Recommendation Report for Planning Permission for Works or Extension to a Dwelling

REF NO: EP/104/21/HH

LOCATION: 8 Selhurst Close
East Preston
BN16 3SR

PROPOSAL: Conversion of garage to habitable use, new garage & single storey extension to West elevation.

Drawing no 11893-1f

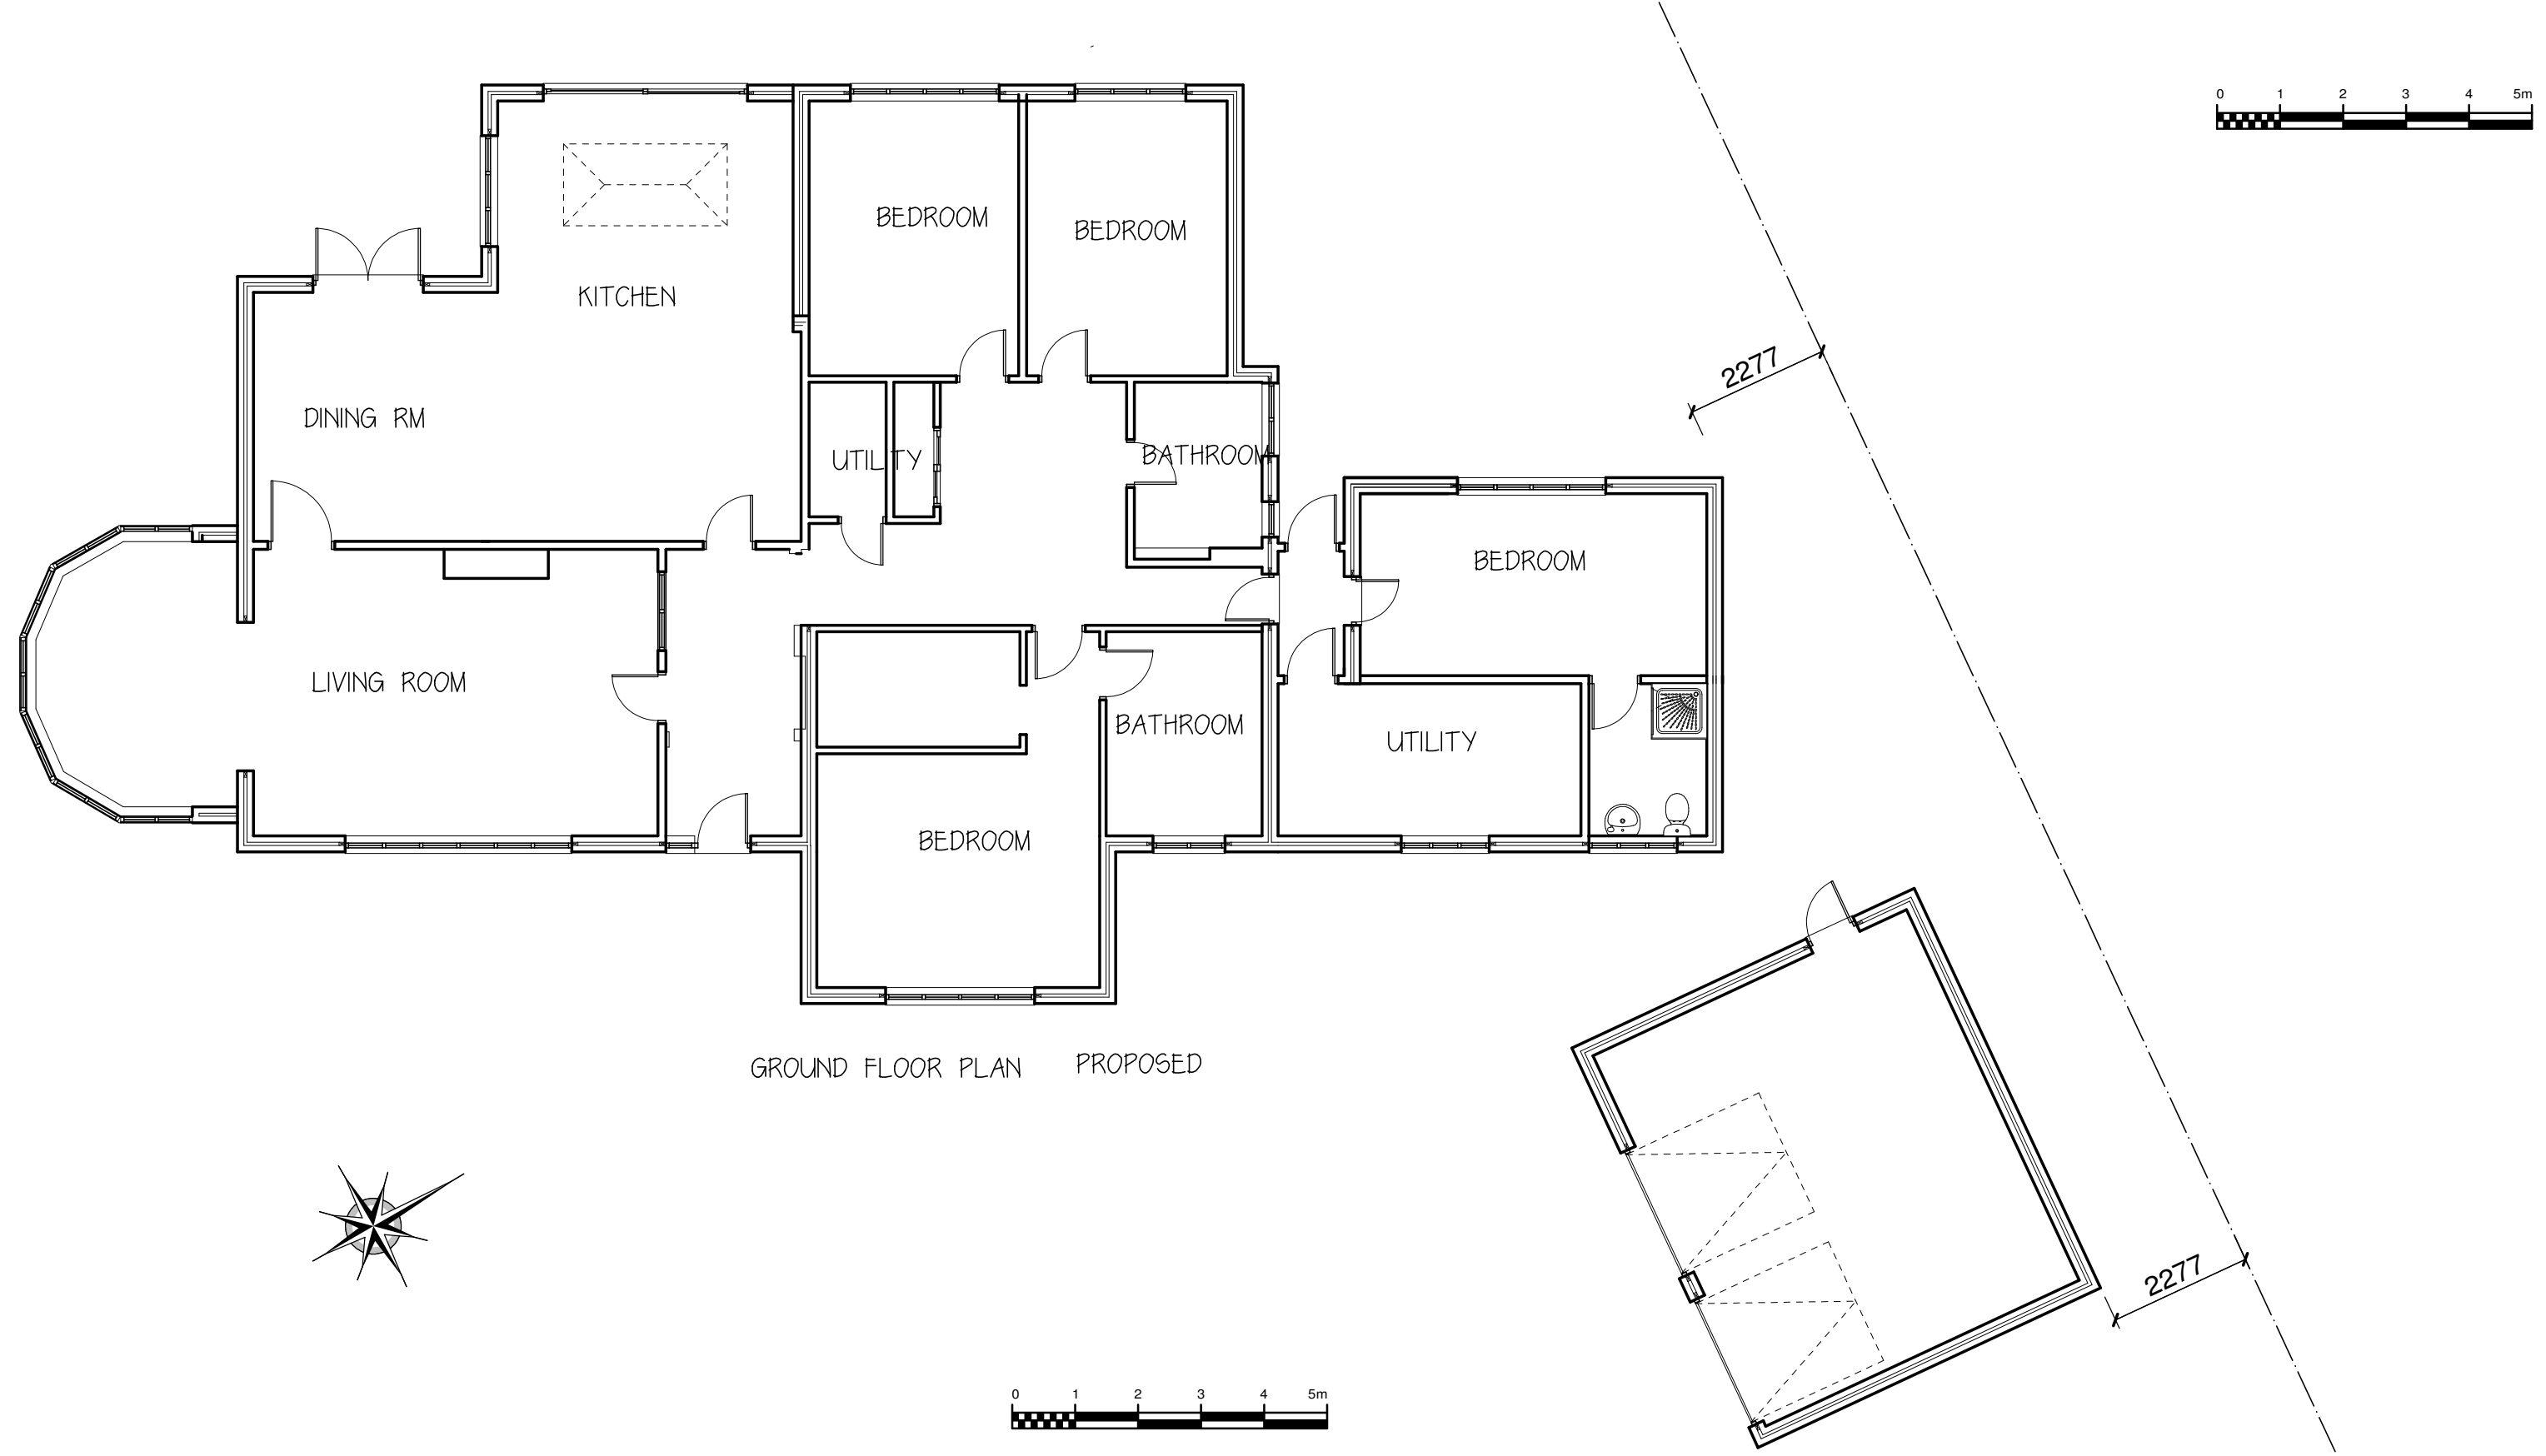
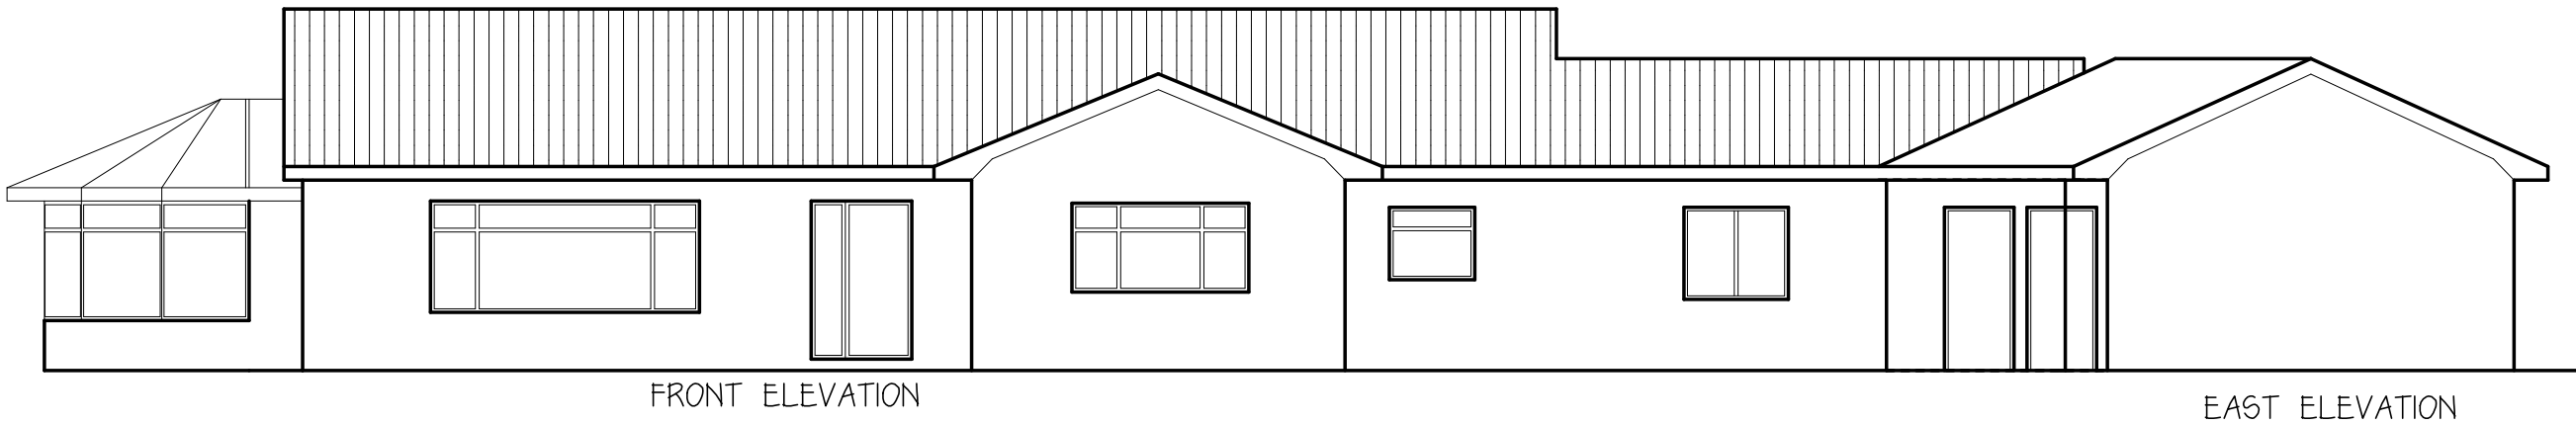
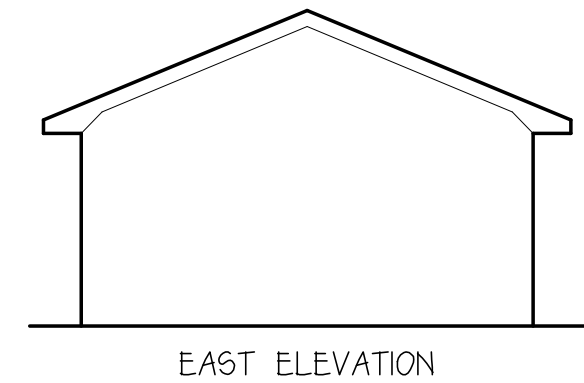
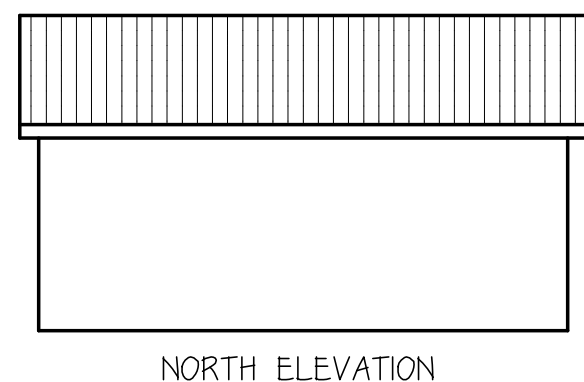
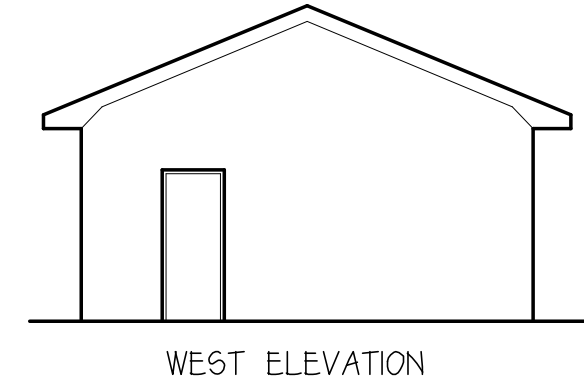
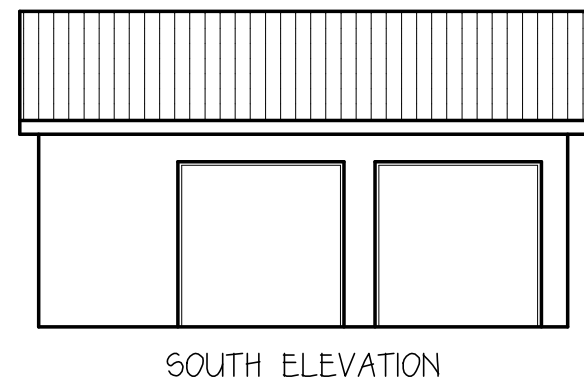
Views of the garage conversion and proposed double garage will be possible from Myrtle Grove. The alterations to the fenestration to the front of the property are considered minor and would fall under the properties Permitted Development allowance. The garage will be set forward of the next door neighbour's (No.10 Myrtle Grove) building line by approximately 2.5m. Given that the building line of Myrtle Grove isn't particularly strong, this is not seen as a reason to refuse the application. Due to the garages location at the back of site when viewed from Selhurst Close and against the back drop of the buildings in Myrtle Grove, it is considered not to compromise the spatial character of the area.

The garage will be built over 2m away from the property to the North in Myrtle Grove which is inline with existing northern building line between the properties. The majority of the build will be located adjacent to a garage of the property to the north as such it is considered not to overbear the amenity space of the neighbour. Given the garage's distance to the boundary the potential for overshadowing is minimal.
